STATE OF NORTH CAROLINA
DEPARTMENT OF TRANSPORTATION

Subject: **Modification Request for Nationwide Permit 23 and Neuse Riparian Buffer Authorization** for the Replacement of Bridge No. 43 over Rainbow Creek on SR 1438; Greene County; TIP Project B-4127; Federal Aid Project No. BRZ-1438(5); State Project No.8.2180401; WBS 33480.1.1.

The purpose of this letter is to request modifications to the Clean Water Act (CWA) Section 404 Permit issued by the USACE and the Neuse Riparian Buffer Authorization issued by the NCDWQ. This project is due to let on May 15, 2007. The North Carolina Department of Transportation (NCDOT) is proposing the following modifications:

5/28/99
FILENAME: ...\\Pr_o\B4127_rdj_psh03.dgn
DATE: 01/16/2006

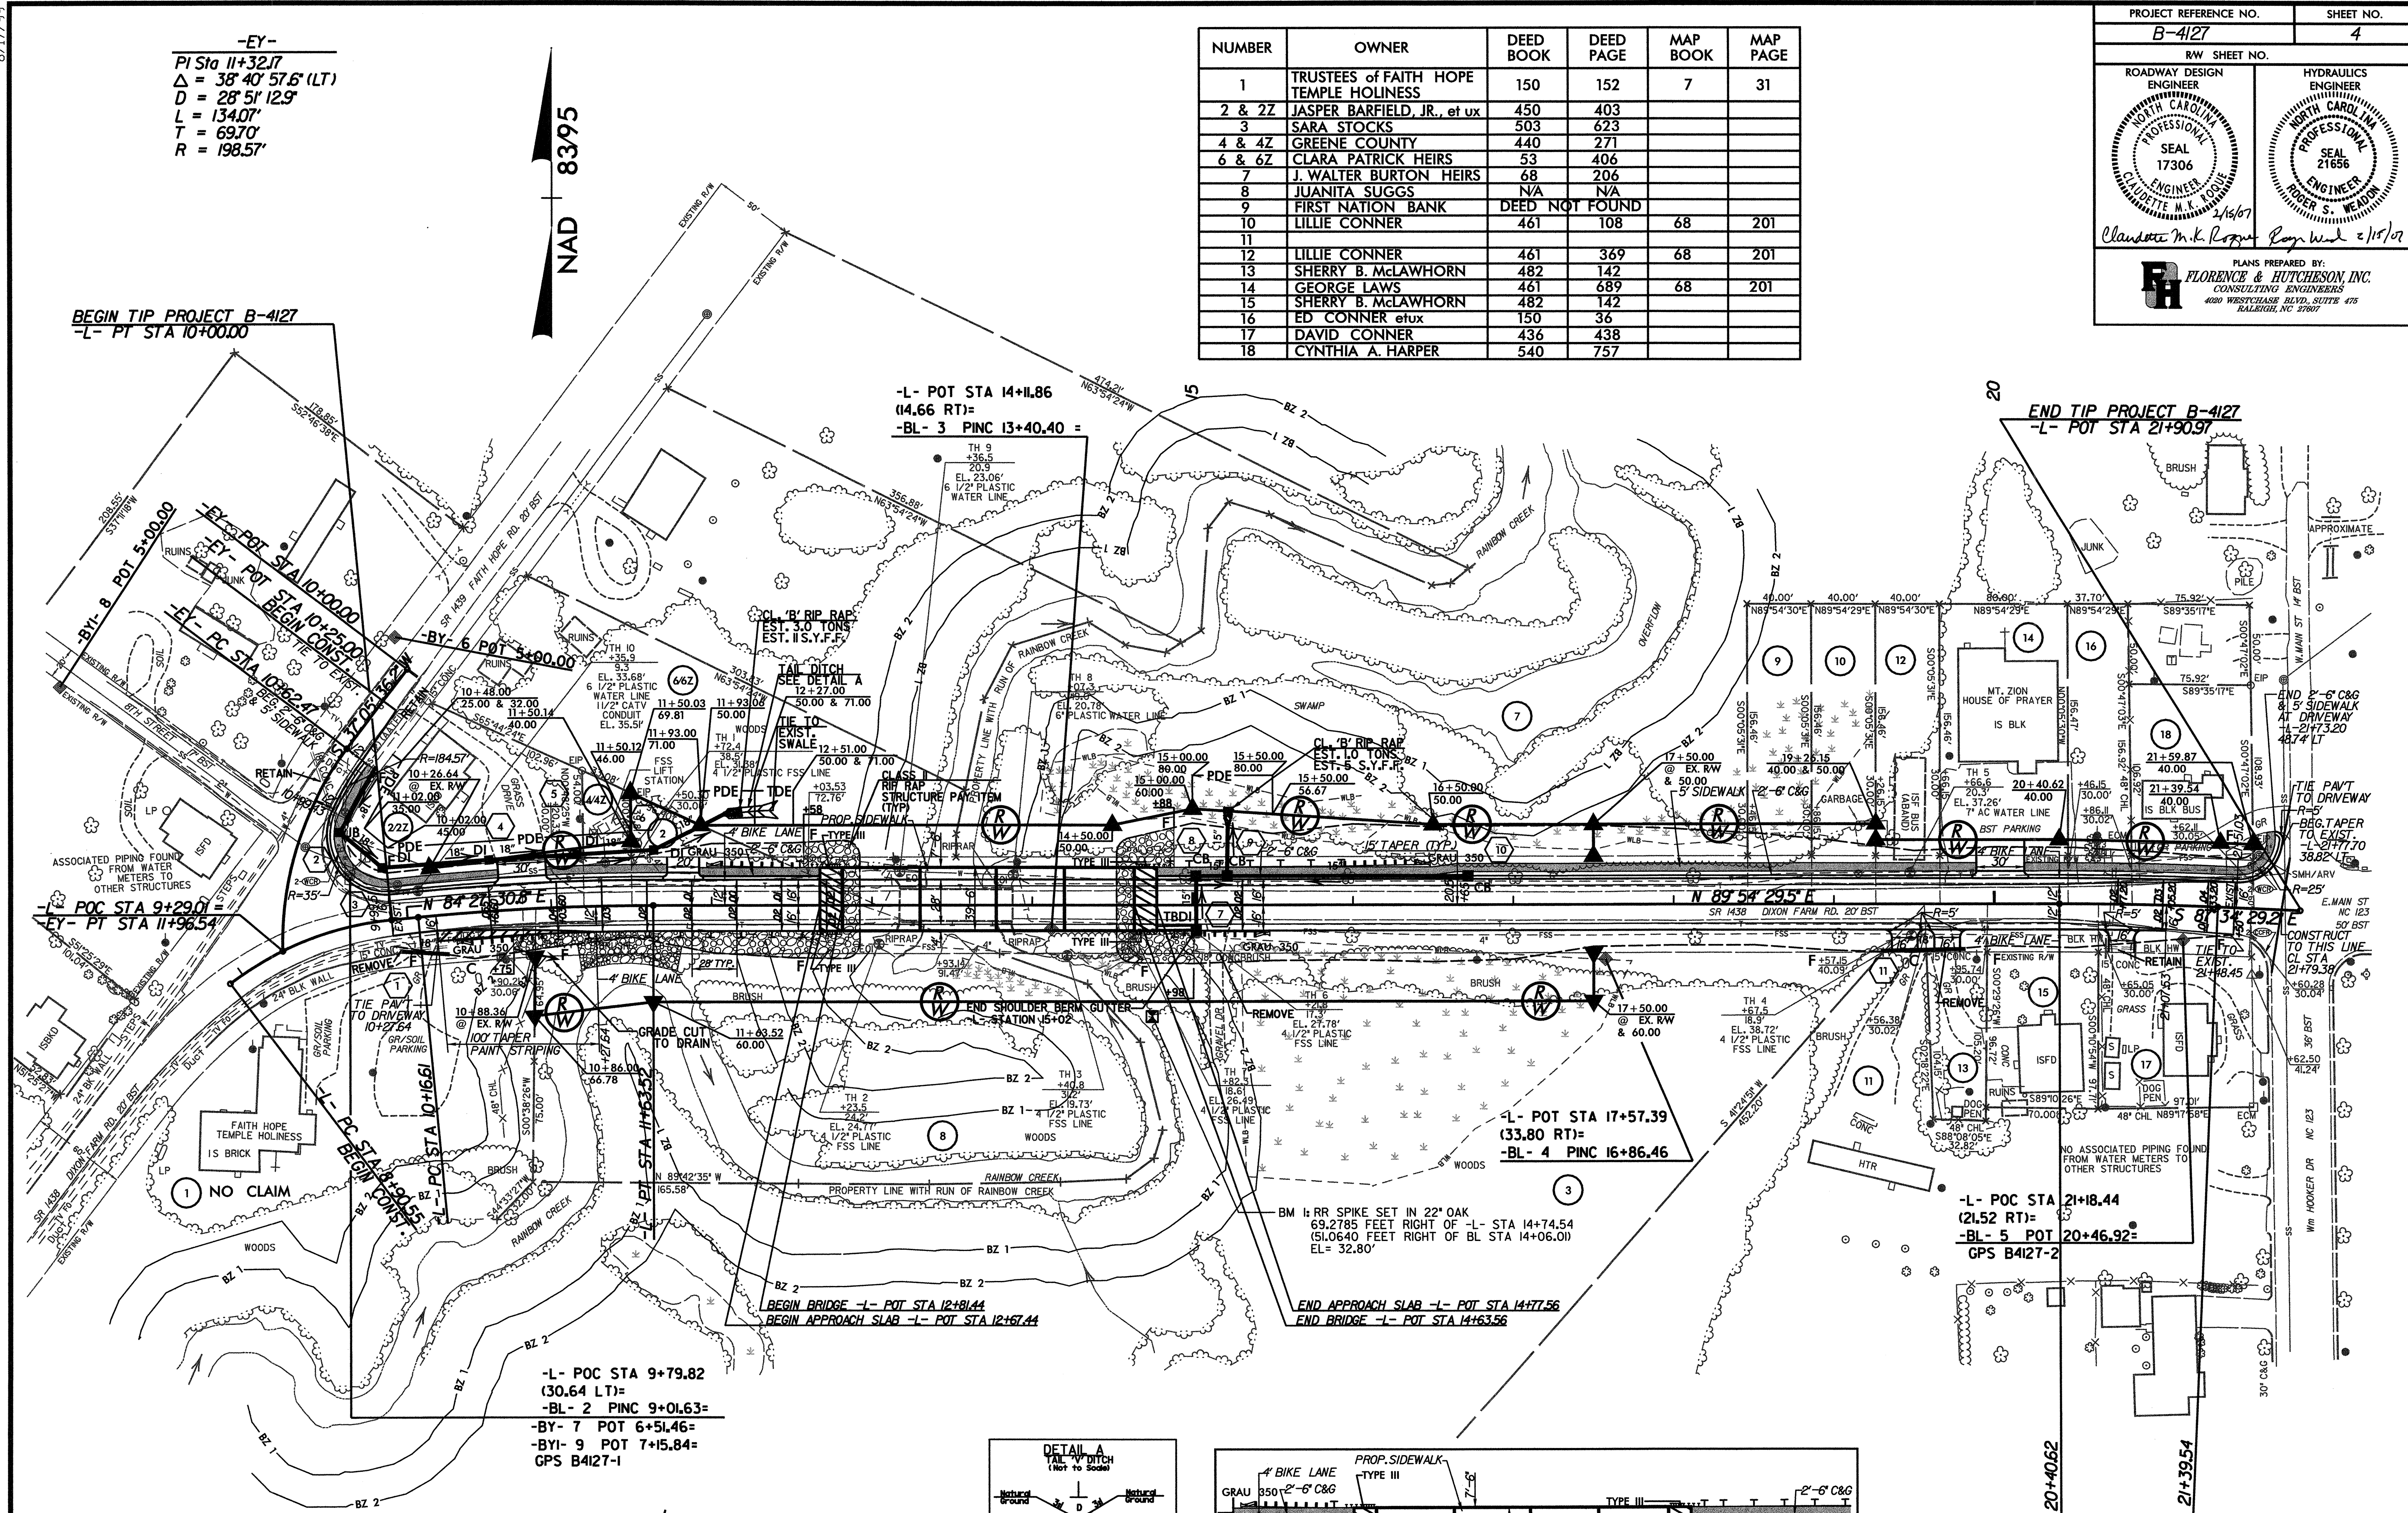
- Add a sidewalk to the proposed project and impact an additional 0.03 acre of riverine wetland.
- Prevent additional loss of bank by adding 0.01 acre of riprap to the horseshoe bend of Rainbow Creek.
- Impact an area of 960 square feet in Buffer Zone 2 for directional bore for the Town of Hookerton waterline.
- Put up a new utility pole for the Town of Hookerton electric line in Buffer Zone 2.
